From: Plant, Tom - Communities <Tom.Plant@Oxfordshire.gov.uk>
Sent: 18 September 2019 15:40
To: Caroline Ford
Cc: DC Support; Cllr Ian Corkin
Subject: 19-01600-F - Bicester Gateway Business Park Wendlebury Road Chesterton

Planning application: 19/01600/F
Location: Bicester Gateway Business Park Wendlebury Road Chesterton
Description: Compound and enclosure for siting of 3 no. LPG tanks within car park of approved hotel
Type: Full Development
Case Officer: Caroline Ford

02 KEY PLAN  
1:500

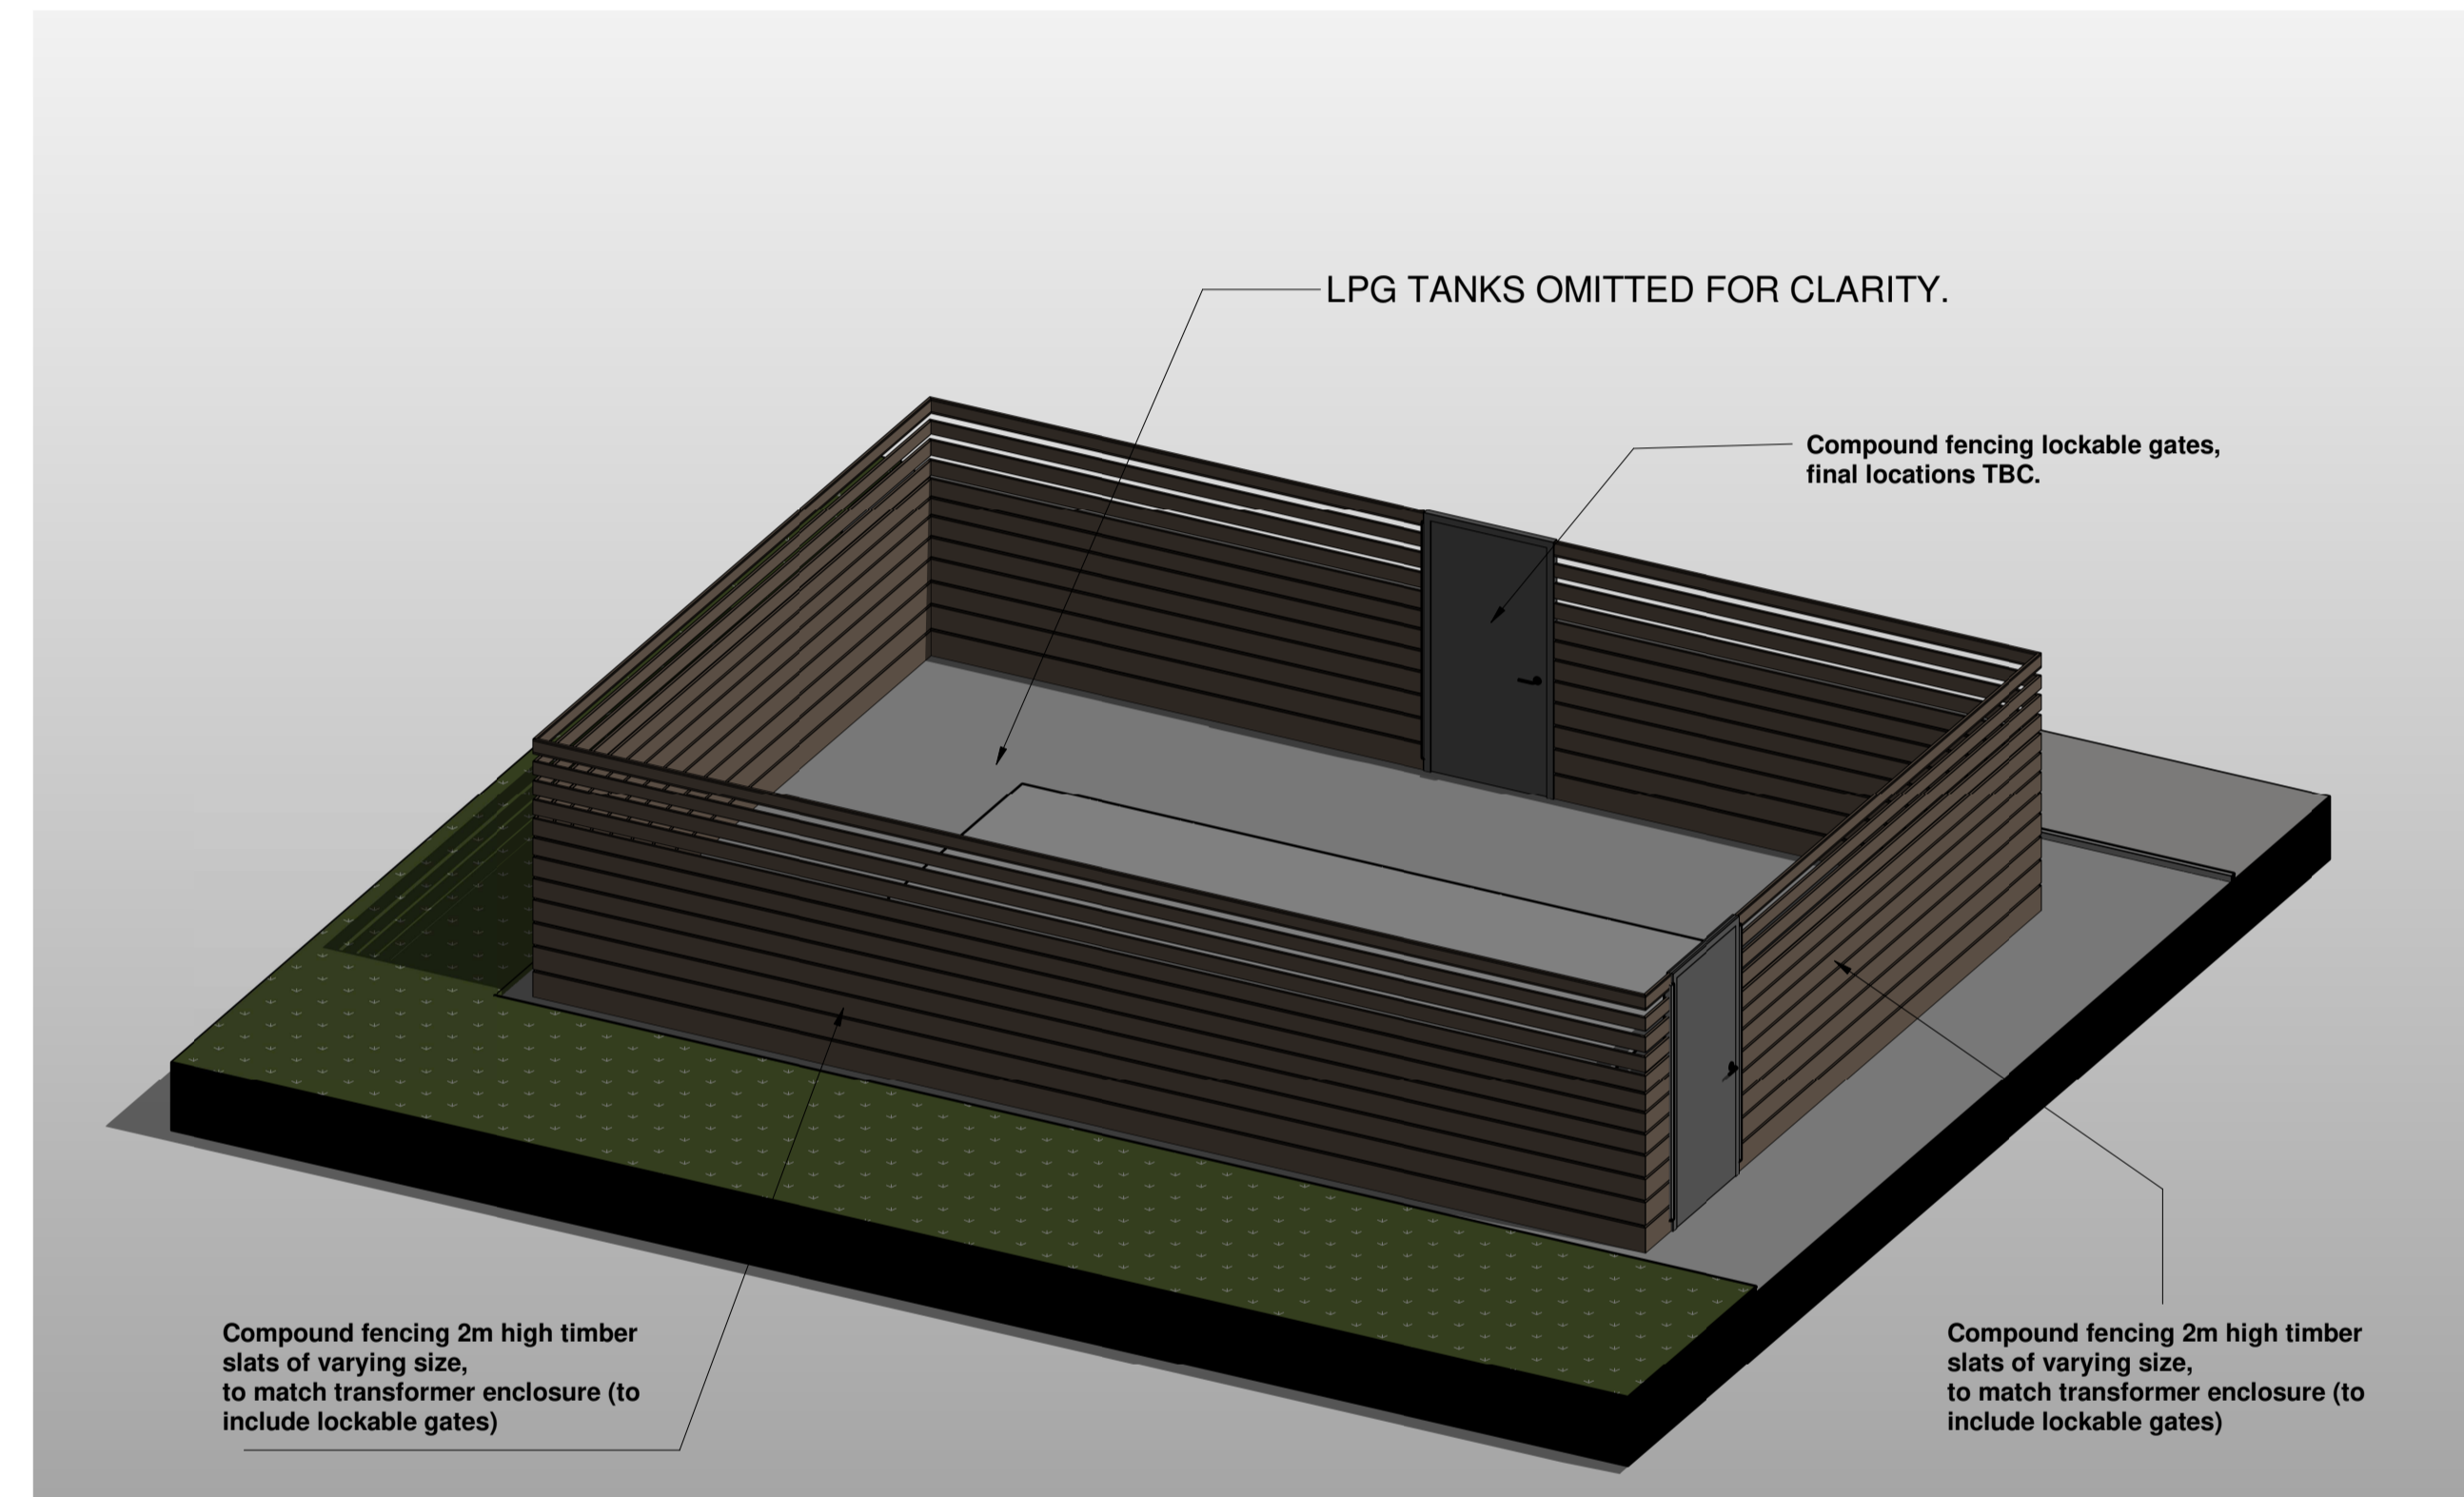
The proposals whilst will lead to a loss of 5 parking spaces, were a situation to arise that the hotel is at full occupancy, other parking opportunities exist within the vicinity including the park and ride site on the opposite side of the Vendee Drive roundabout with the A41. Therefore, the proposals are unlikely to have any adverse impact upon the local highway network from a traffic and safety point of view, therefore I offer no objection.
